TOWN AND COUNTRY PLANNING ACT 1990 FULL

Reference:	H09-1130-21	Date of Decision:	23rd December 2021
Applicant:	Mr J Bingham C/O Tac Architects 14 Old Fendike Road Weston Hills Spalding PE12 6DD		
Location:	Plot Rear Of 2 Cranmore Lane Holbeach Spalding		
Description:	Proposed bungalow and detached garage

PROPOSED BLOCK PLAN

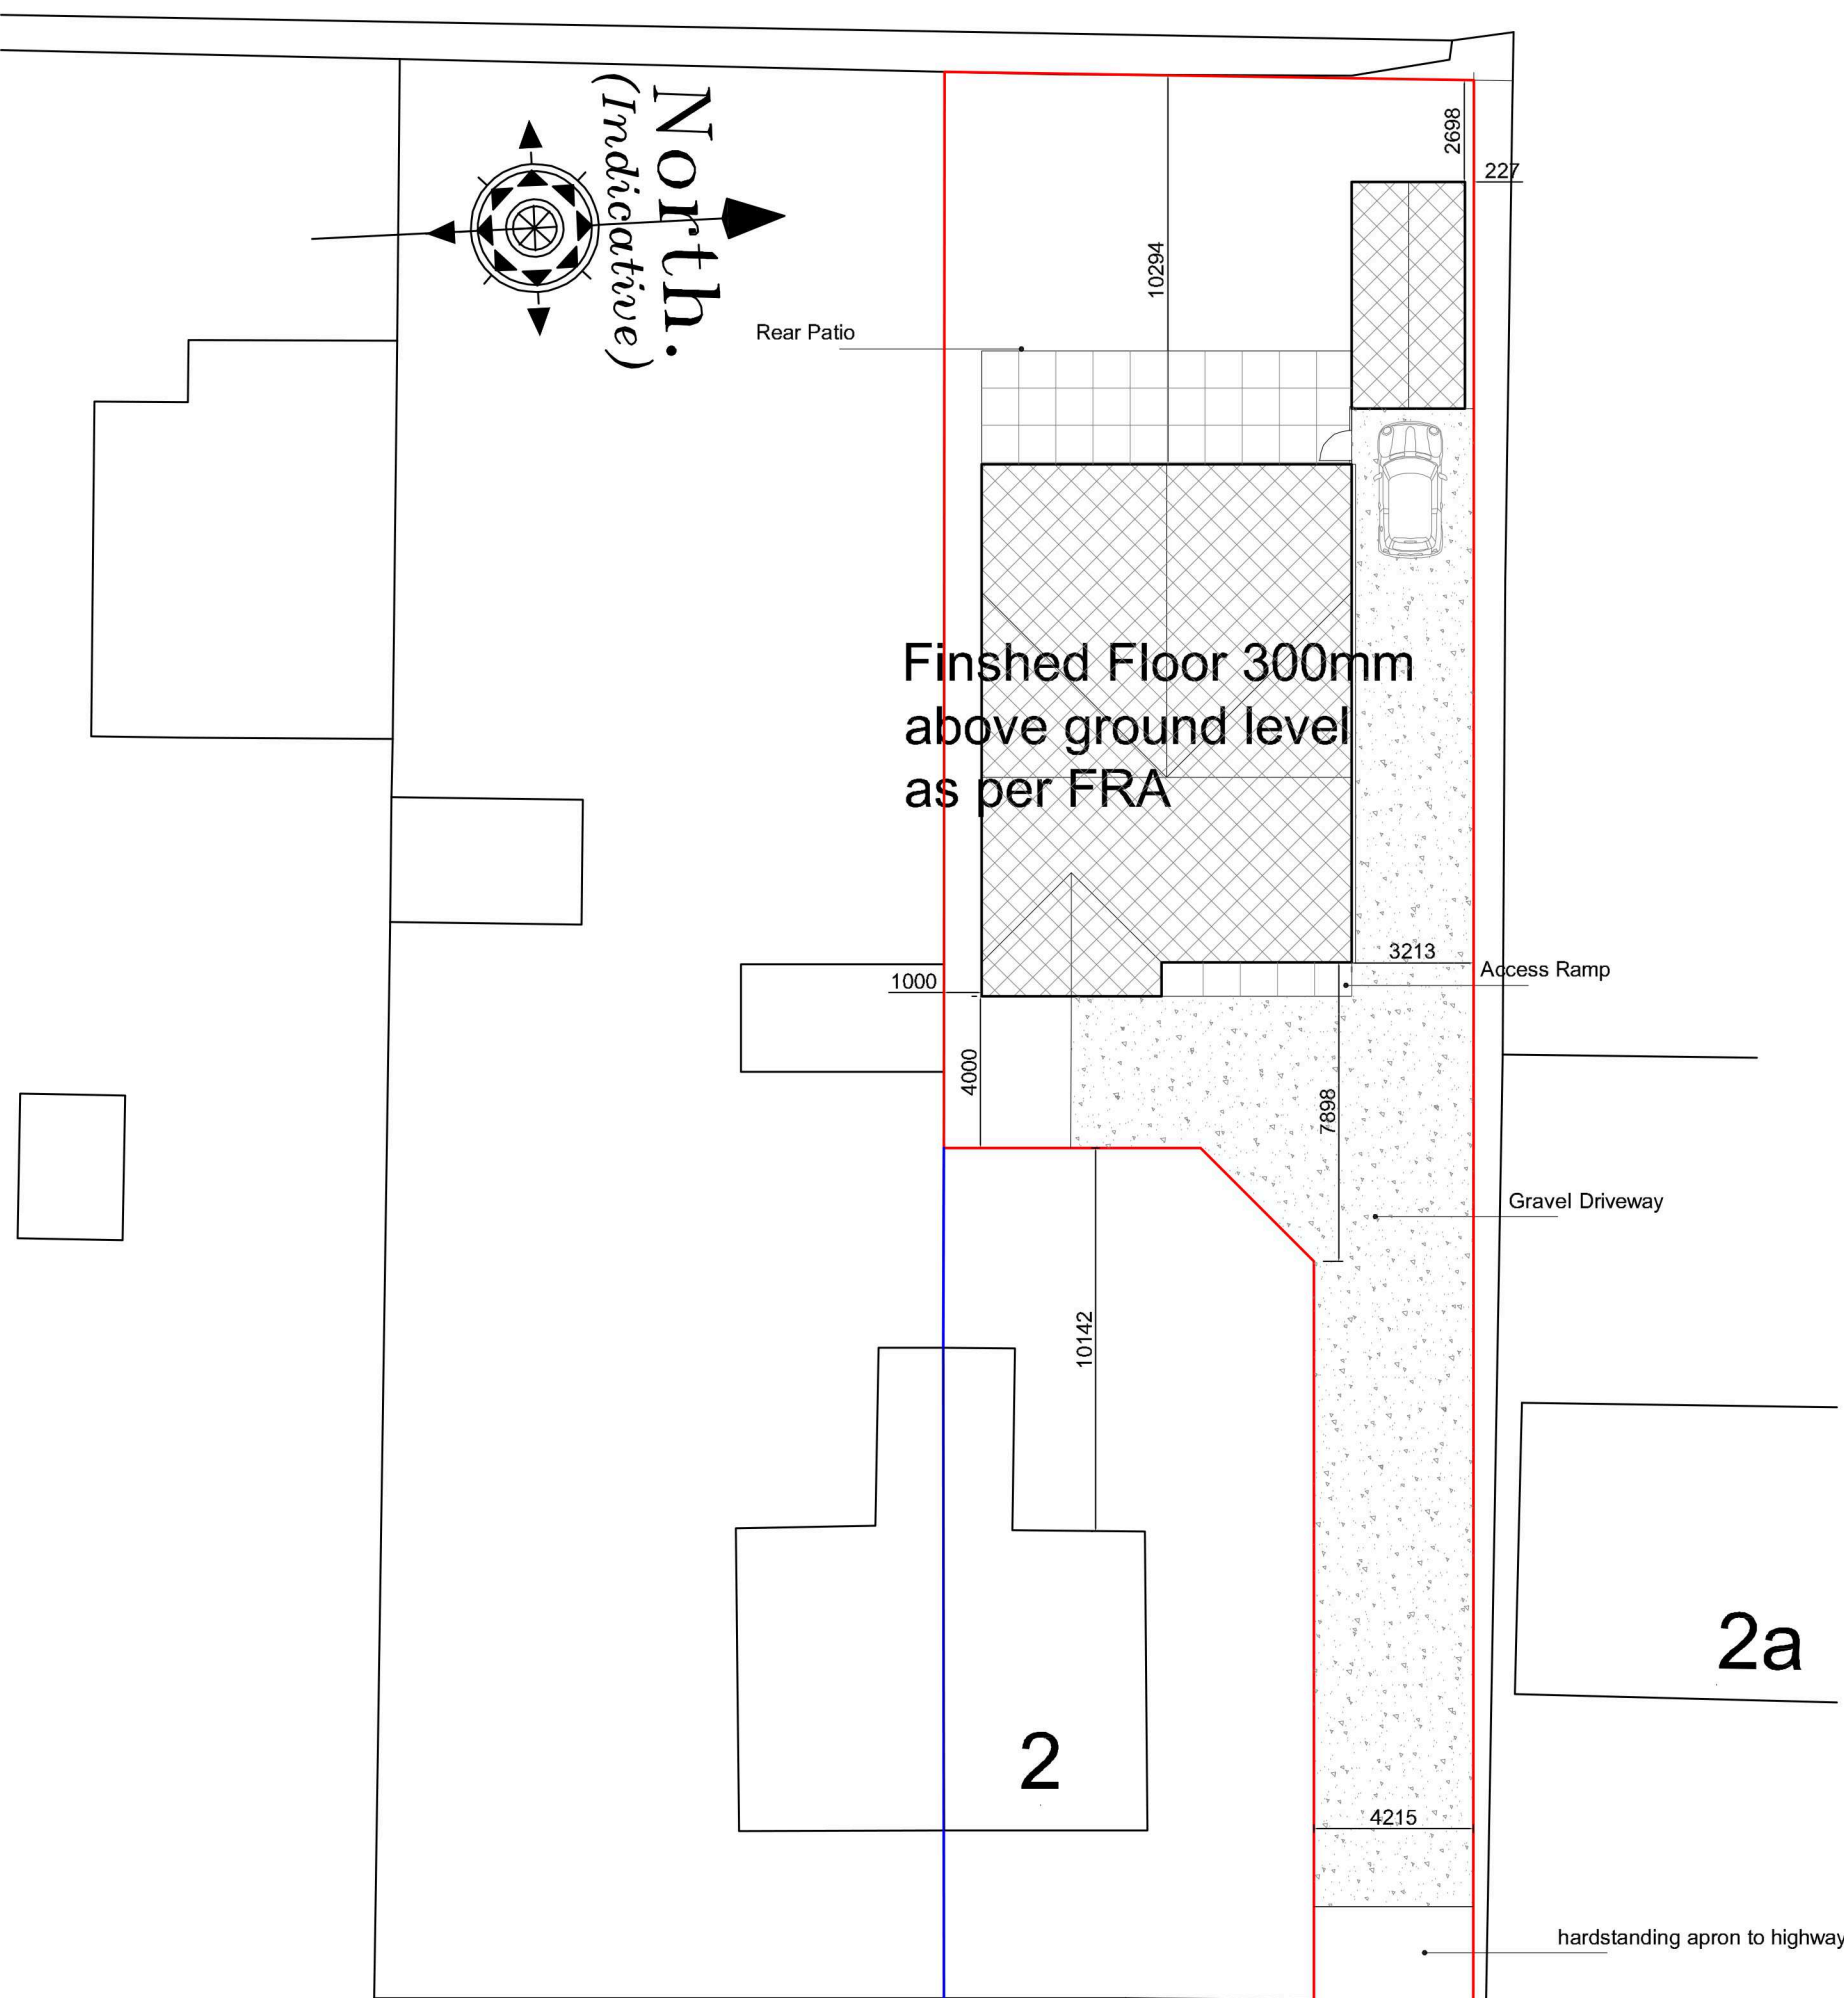
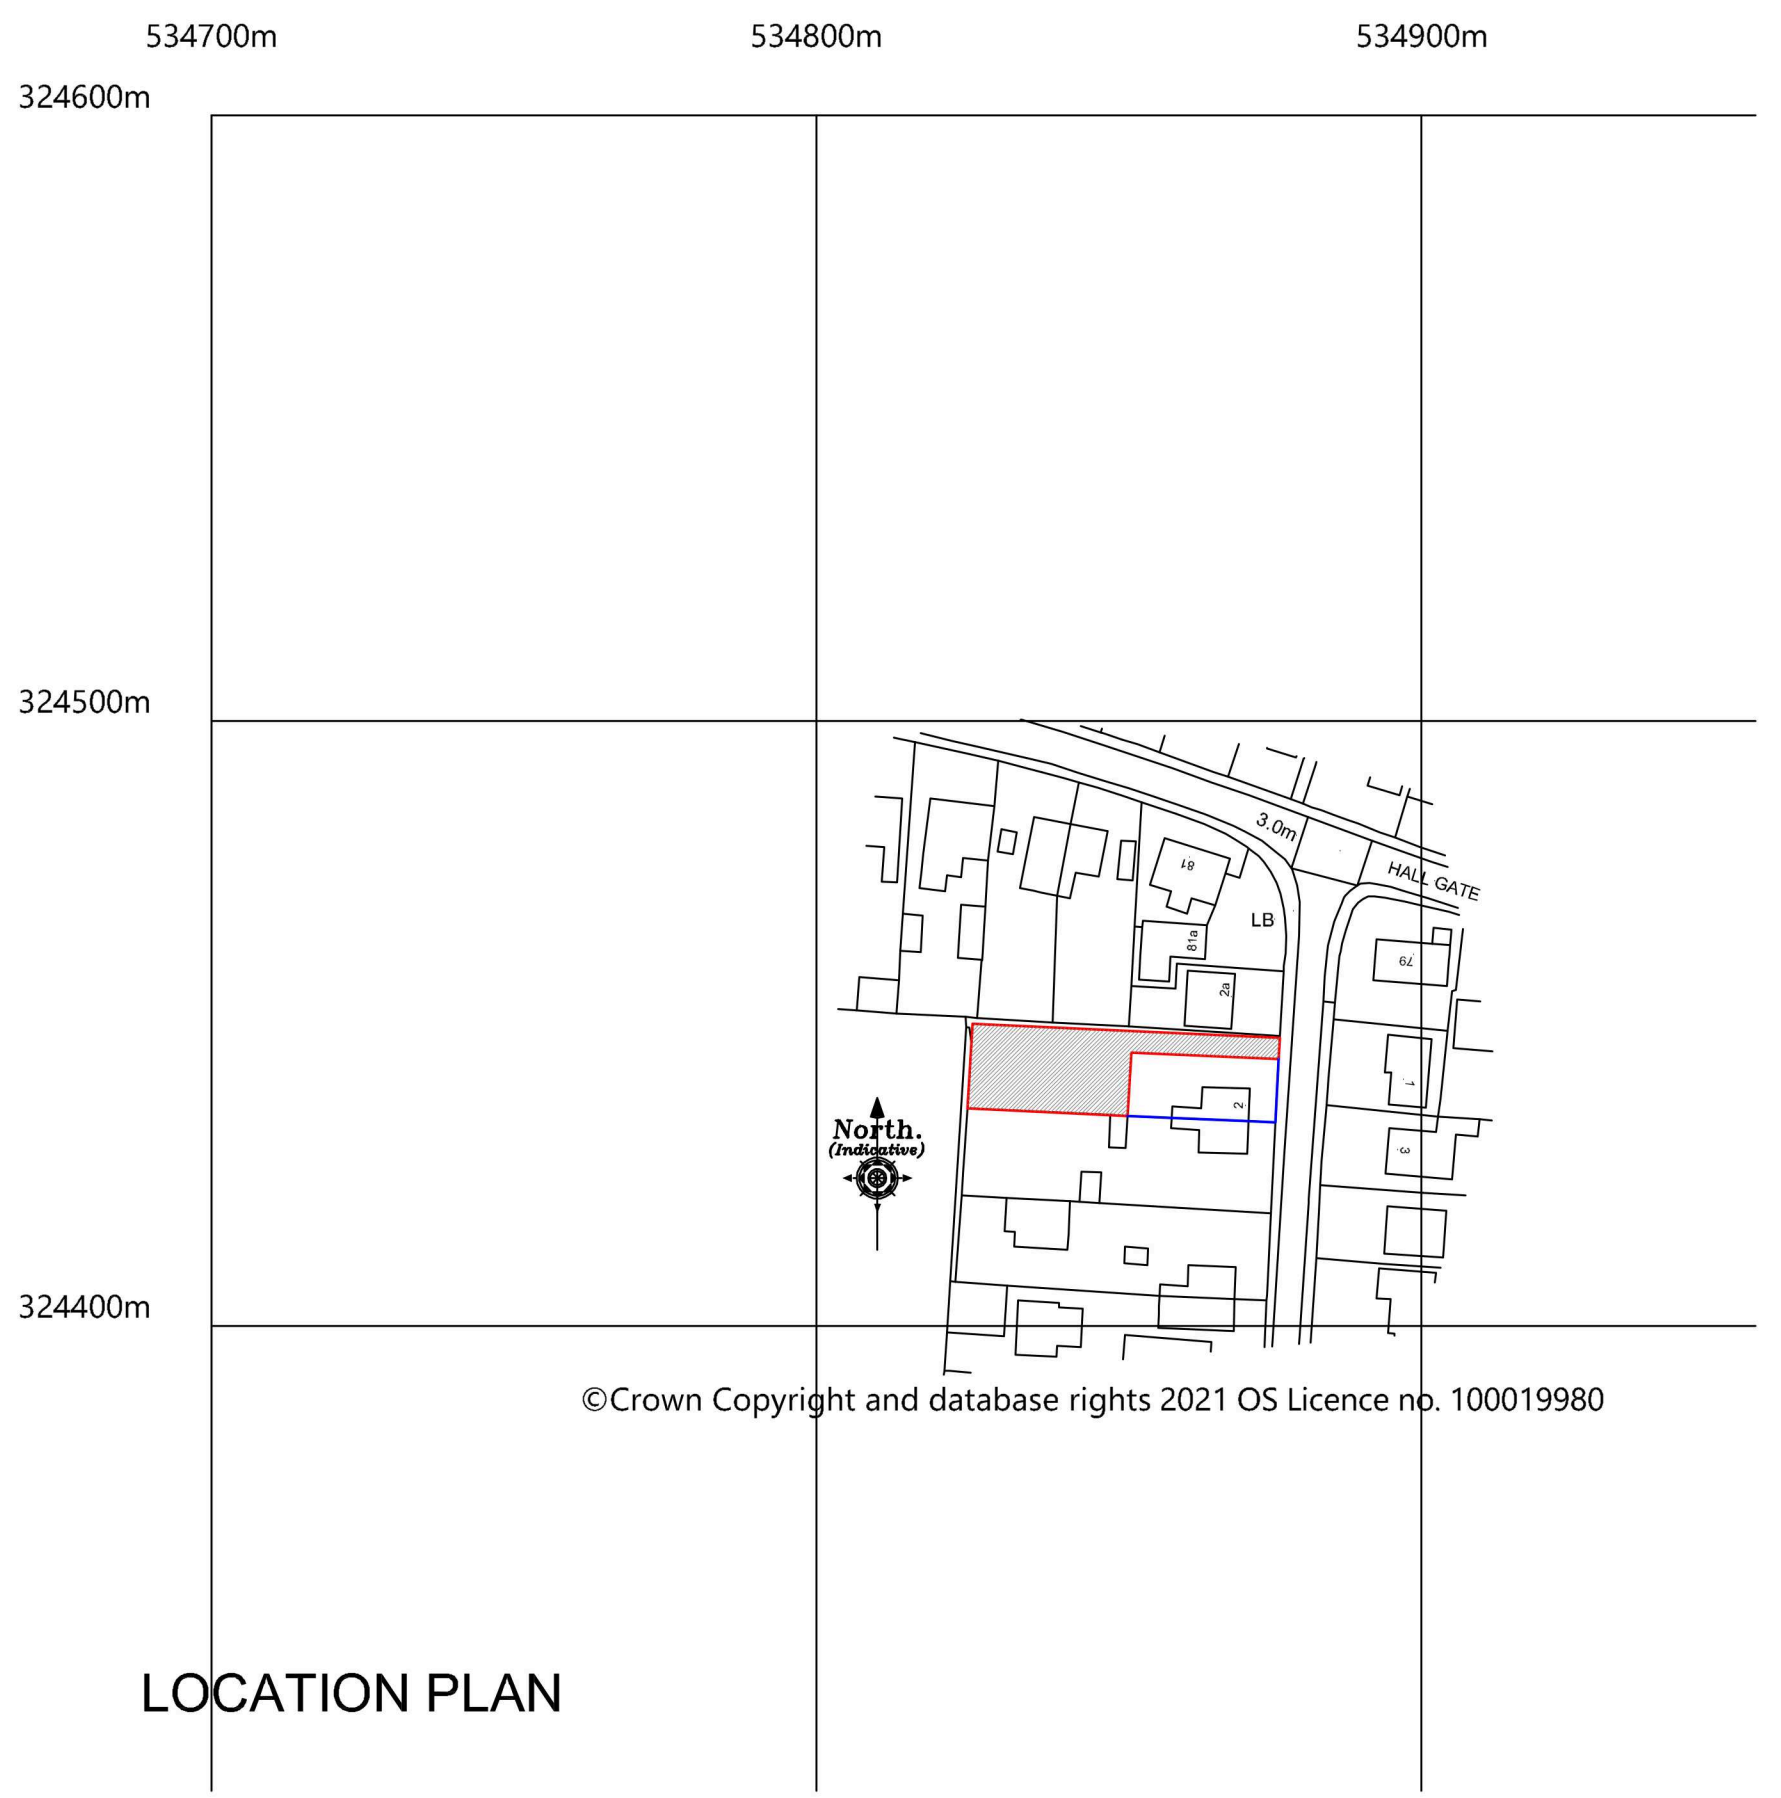
- 1 The site is inside the Holbeach Settlement Limit as defined in the South East Lincolnshire Local Plan (SELLP), 2019. However, the proposal would constitute a cramped and inappropriate form of backland development that would be out of character with the area. Further it is considered the proposed development would materially harm the amenity of nearby residents in terms of noise and disturbance from vehicles using the private drive.
